Application for a Non-Material Amendment Following a Grant of Planning Permission

The proposed development comprises the construction of a new industrial/commercial shed for logistics and distribution use, including ancillary office floorspace, in addition to staff/visitor car parking and landscaping enhancements.

PA22/03143

Non-Material Amendment(s) Sought

Title
Site Layout - Proposed Site Roof Plan

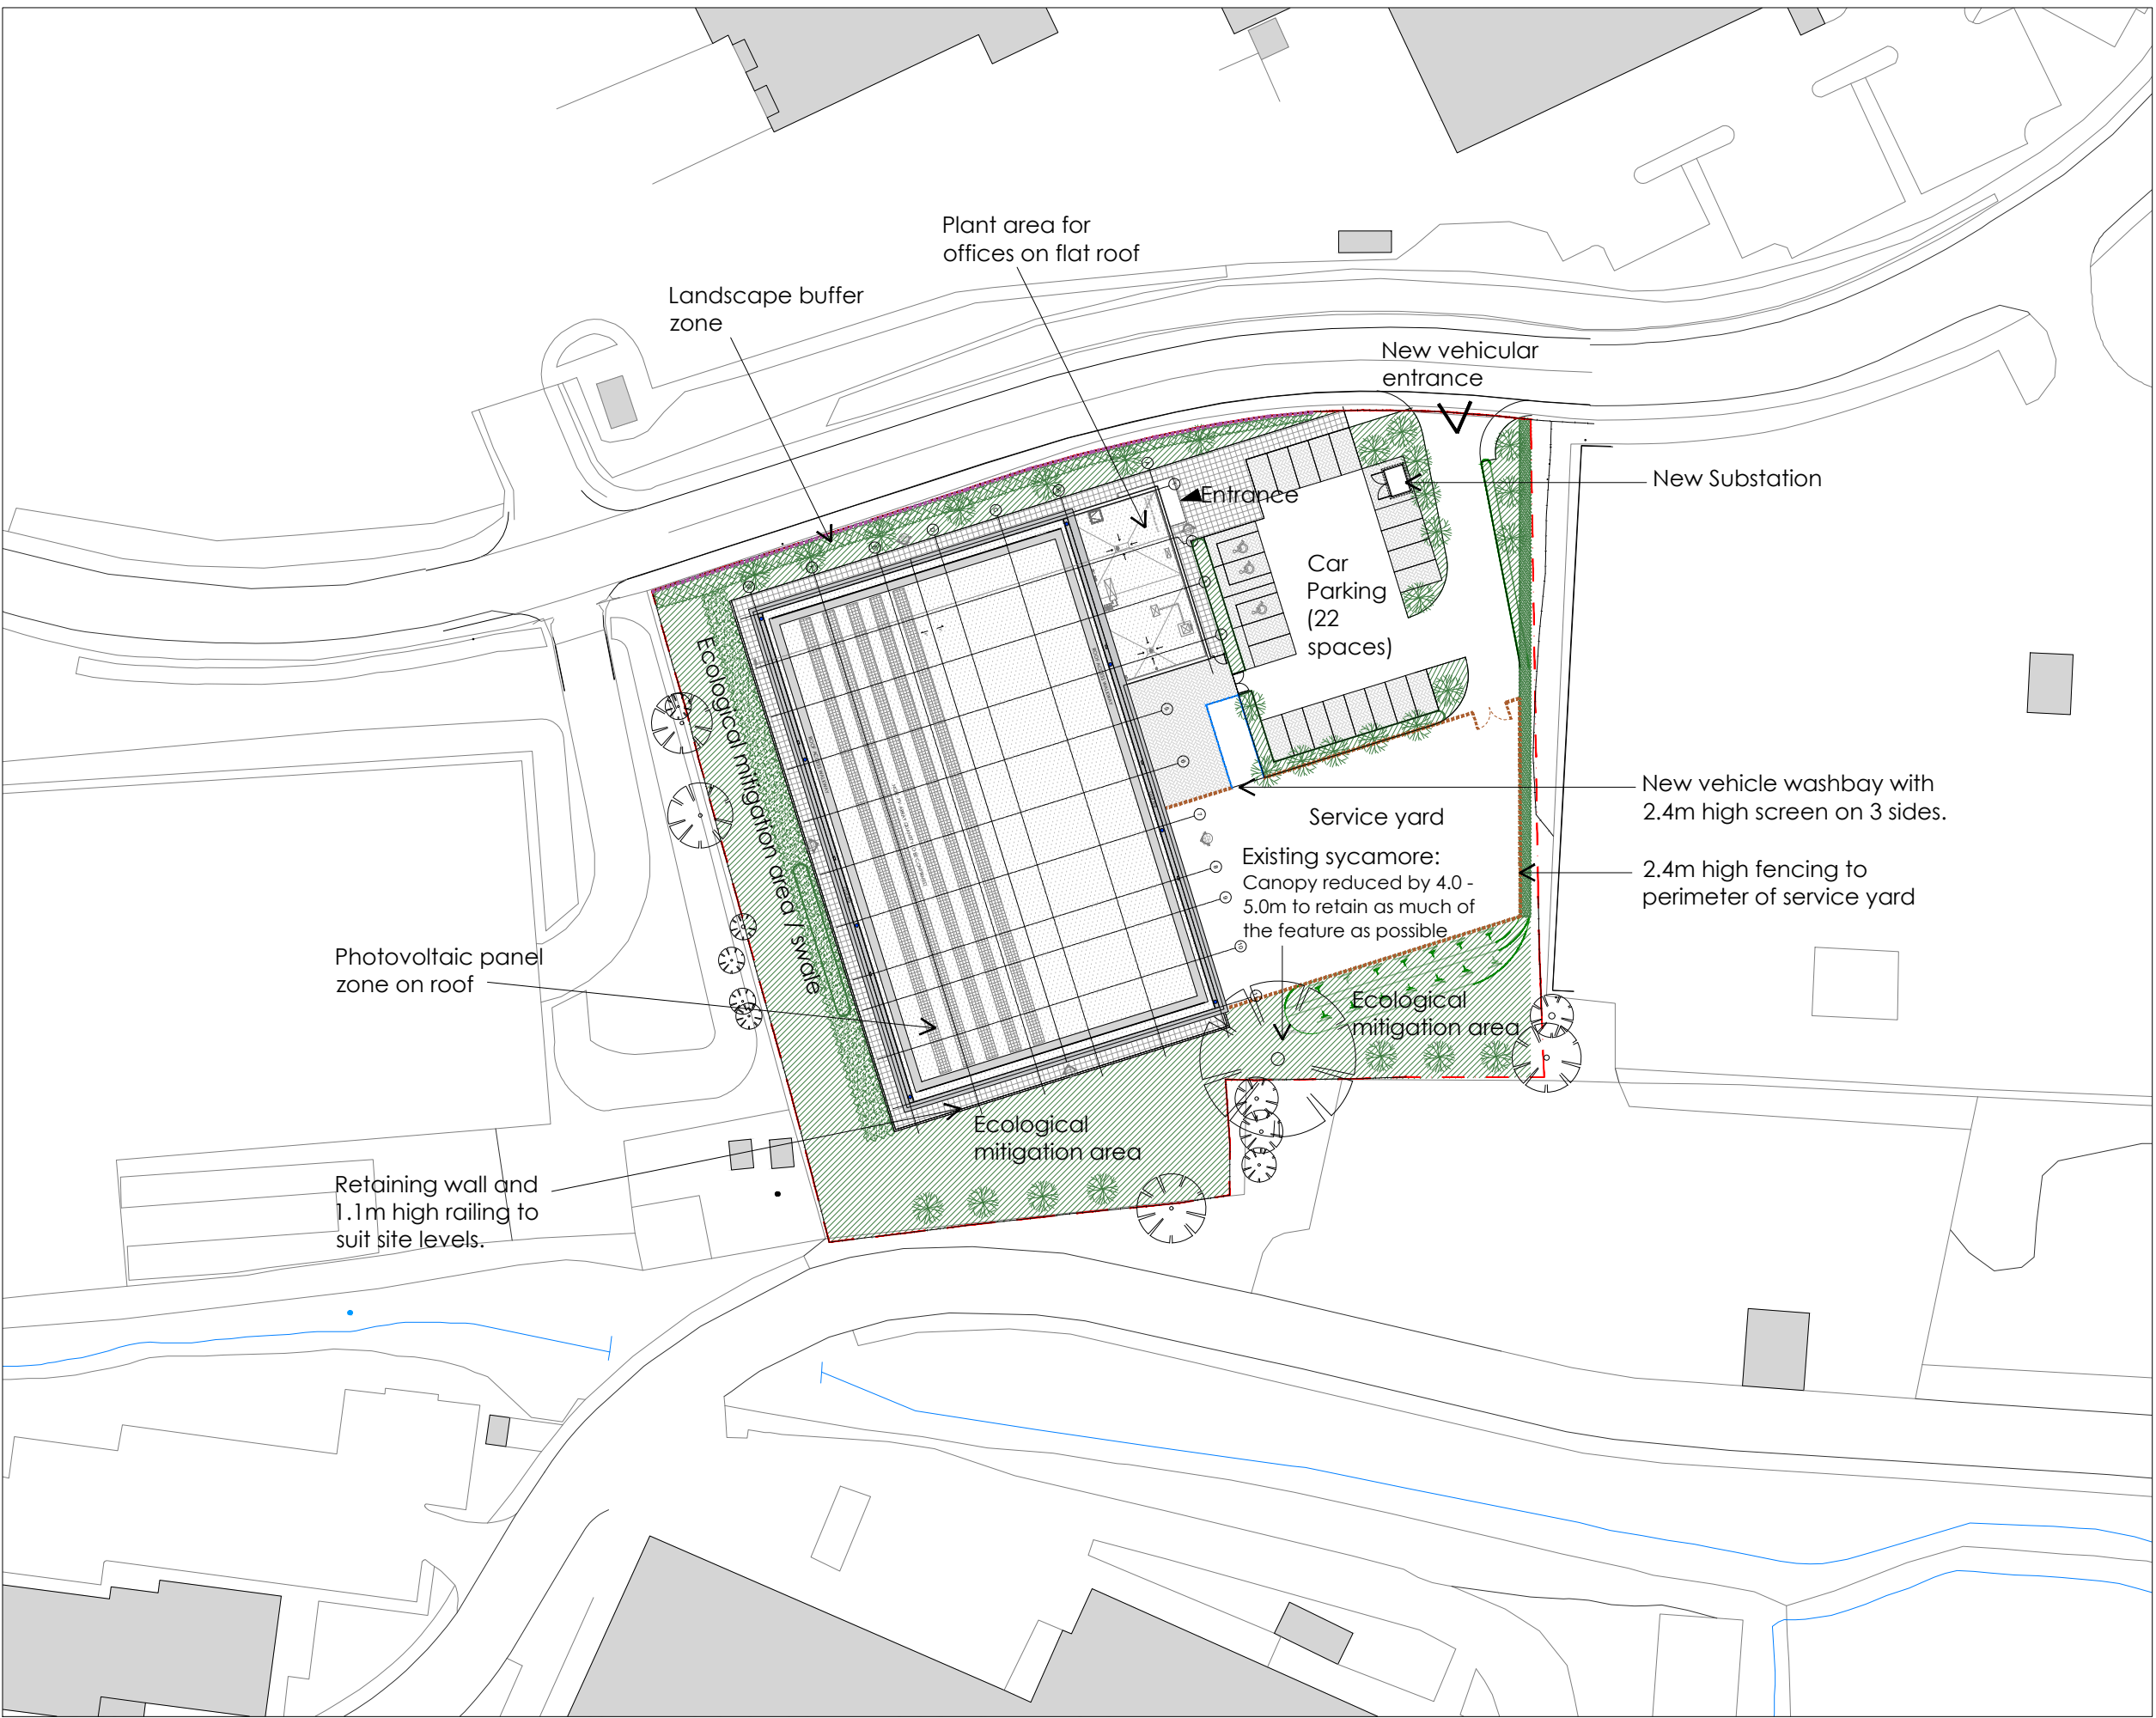
Gable ends changed from flat to pitched parapets and long elevation parapets reduced in height. Ridge height increased due to change in cladding system and non-combustible insulation requirements.

Title  
 Proposed Elevations  
 Sheet 1

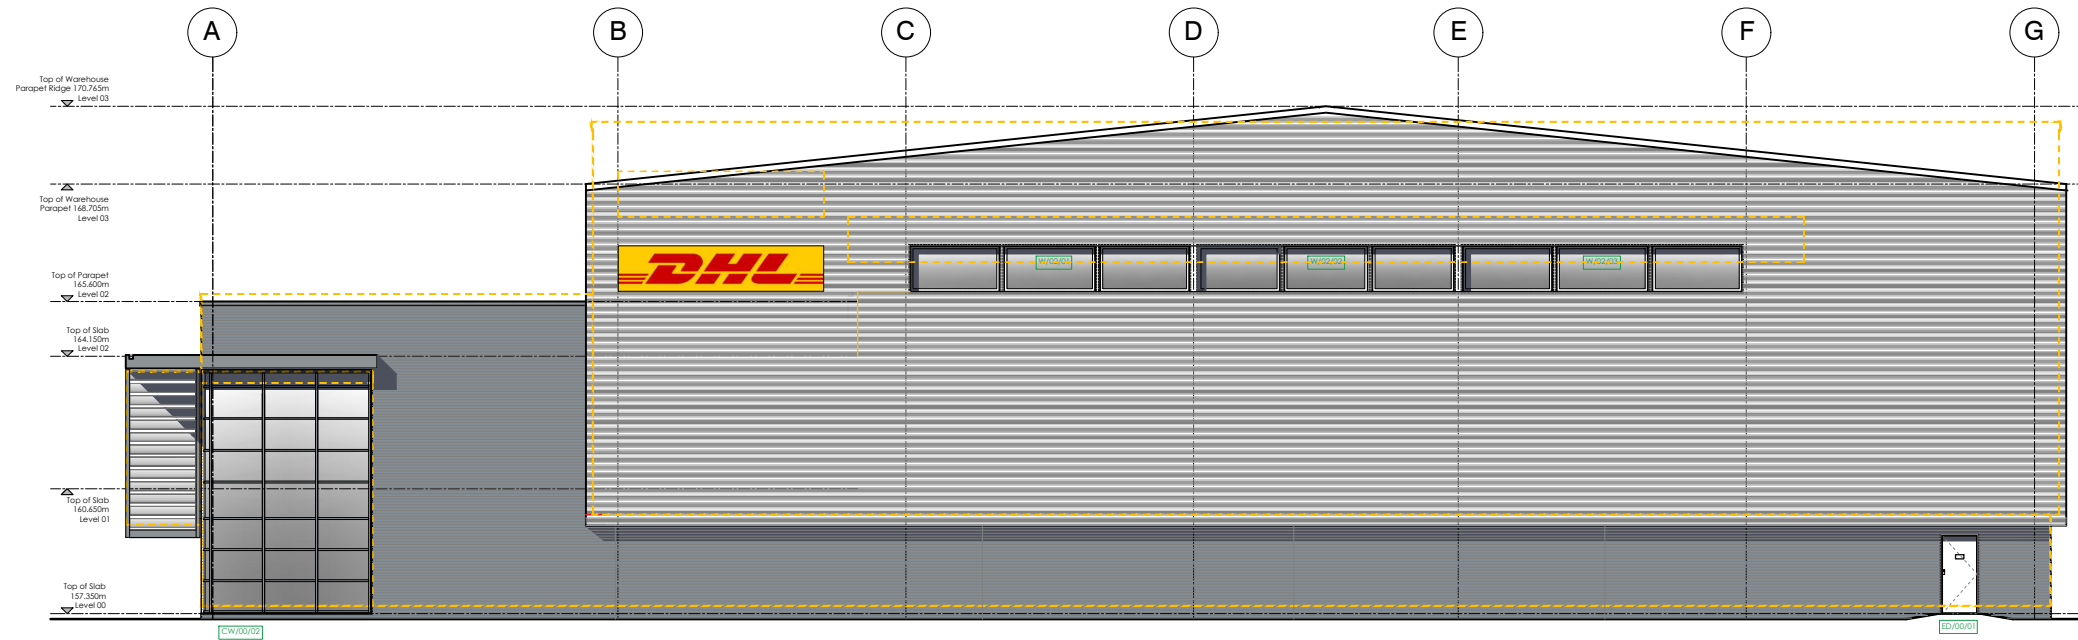
Amendment of brick spec from long format grey to standard format grey.

Amendment of cladding from smooth white panels to profiled white sheets.

Minor amendments to fenestration and louvre setting out.

Title
Site Layout - Proposed Site Plan

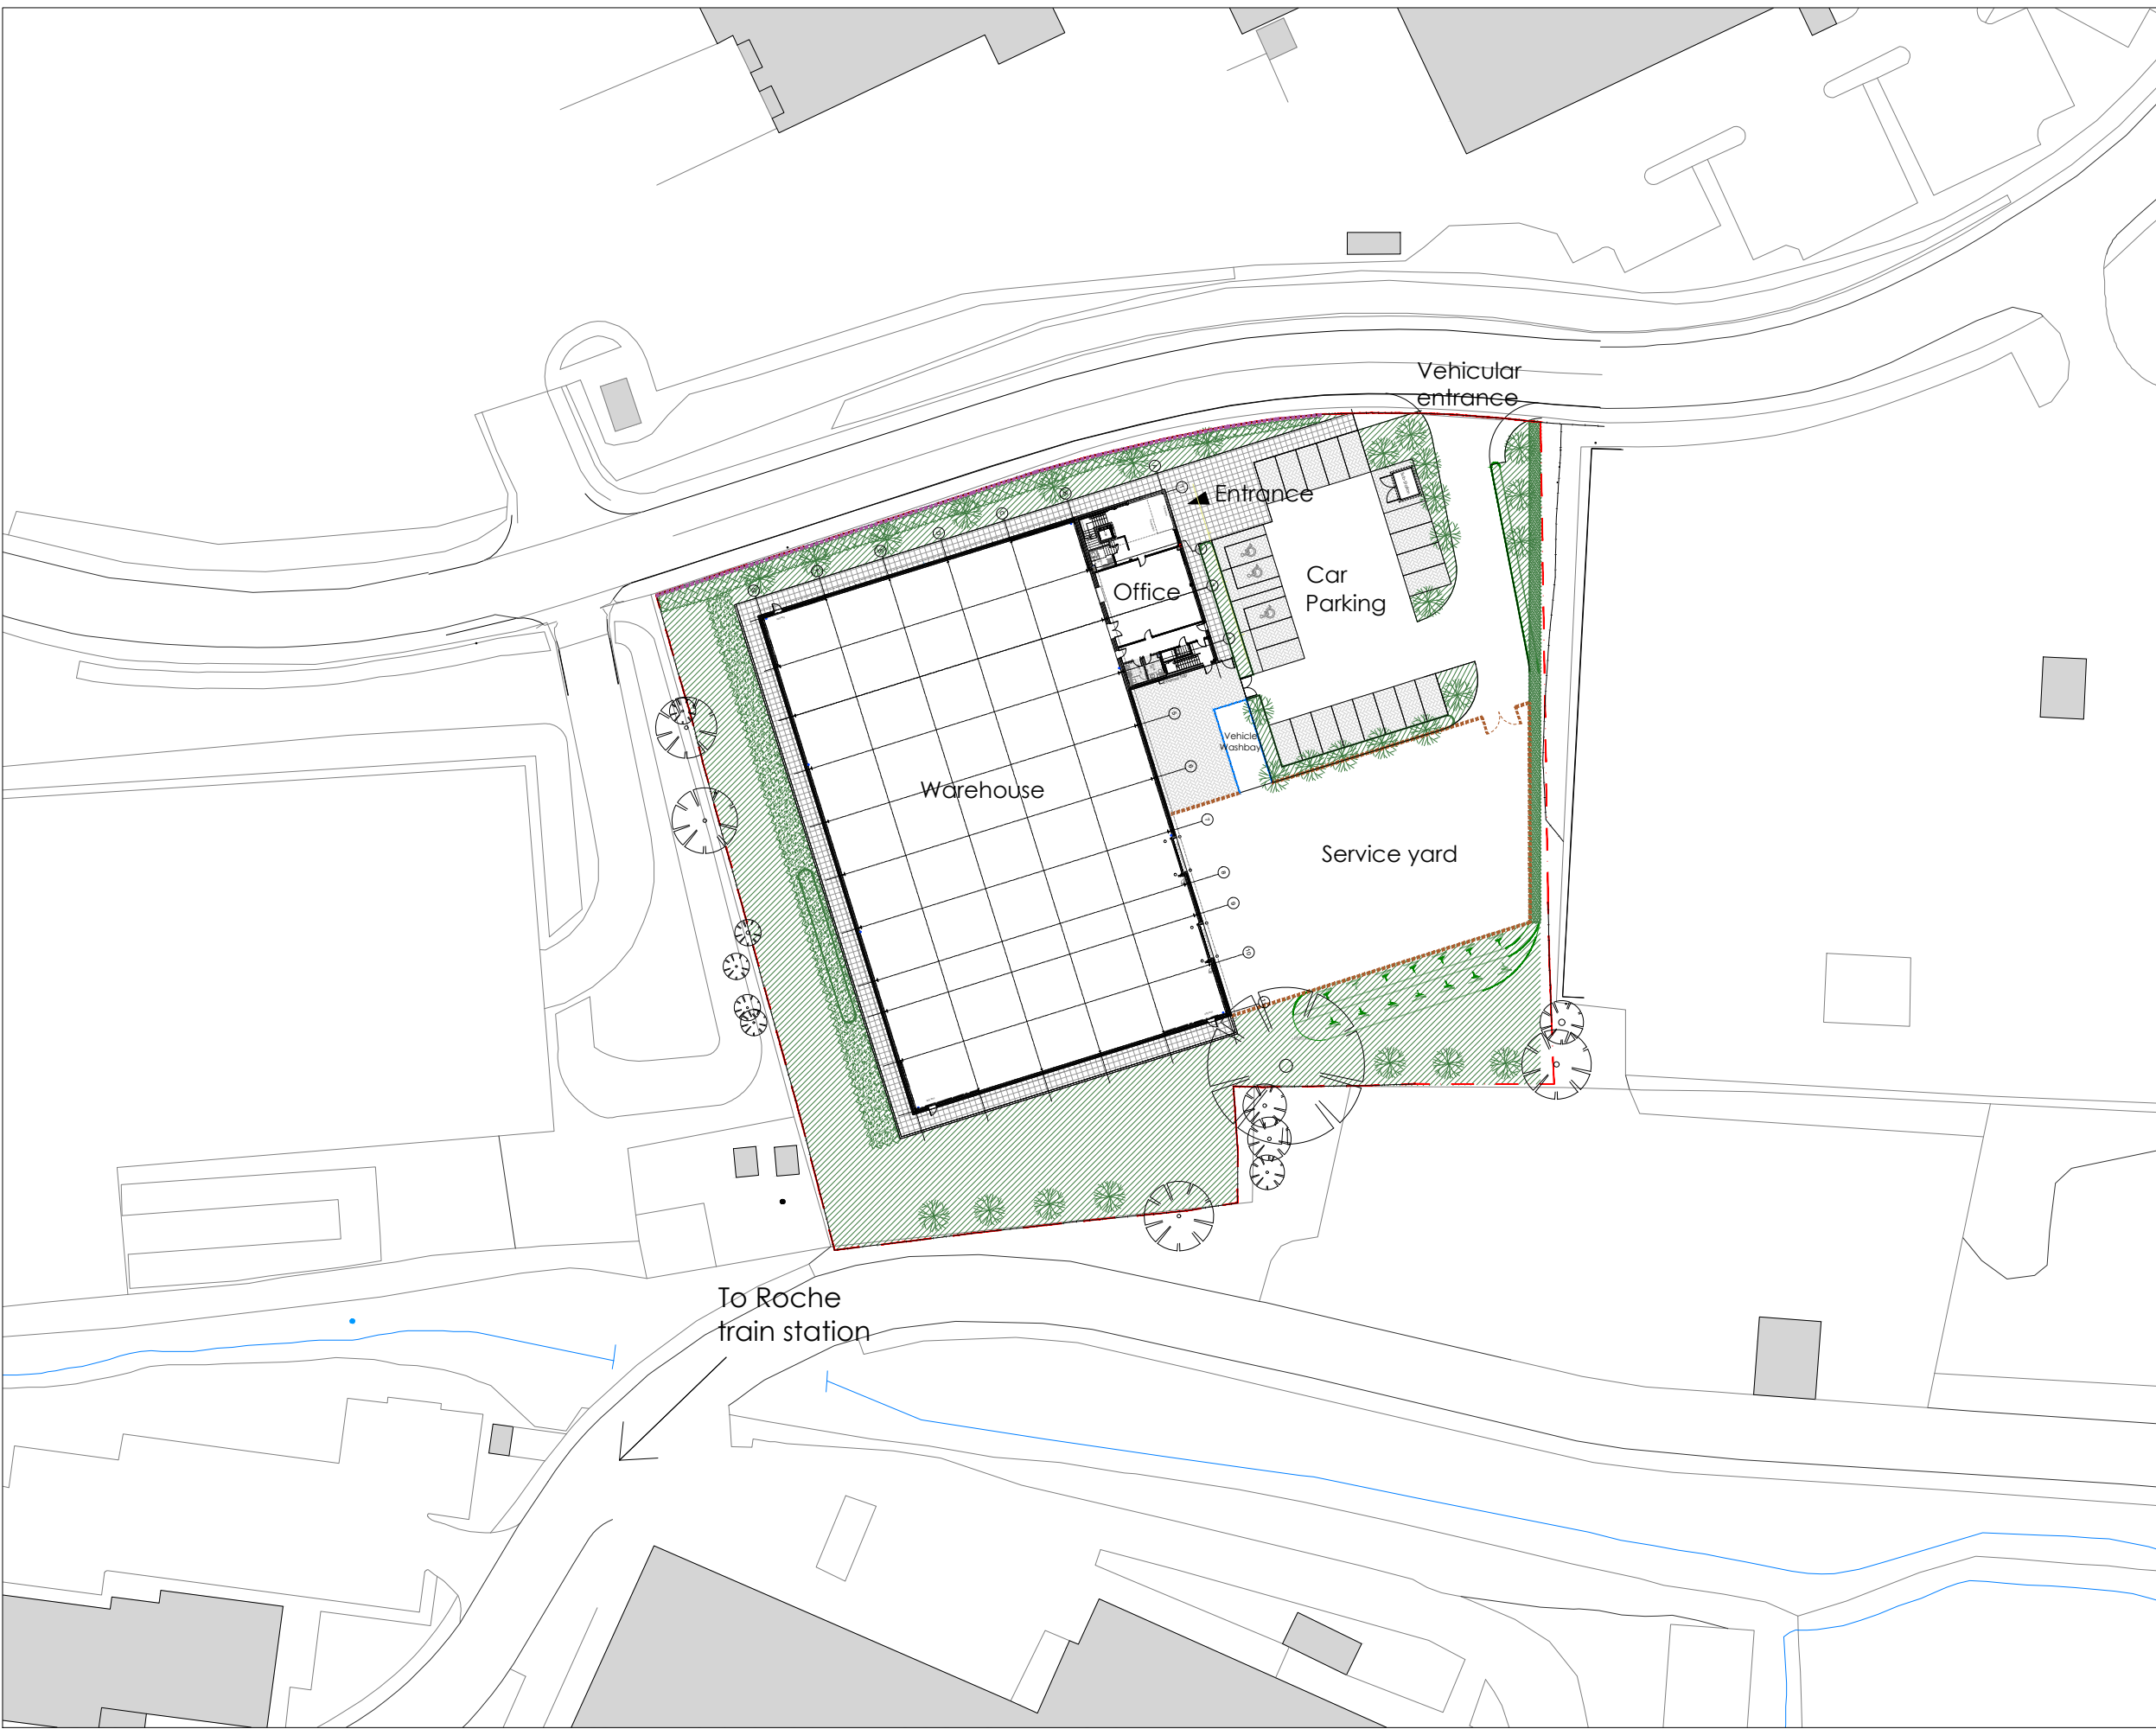
Substation relocated within car park area – no change in number of parking spaces as a result (still 22) or access arrangements.

Removal of pedestrian access along western boundary to allay security and safety concerns expressed by the end user (DHL).
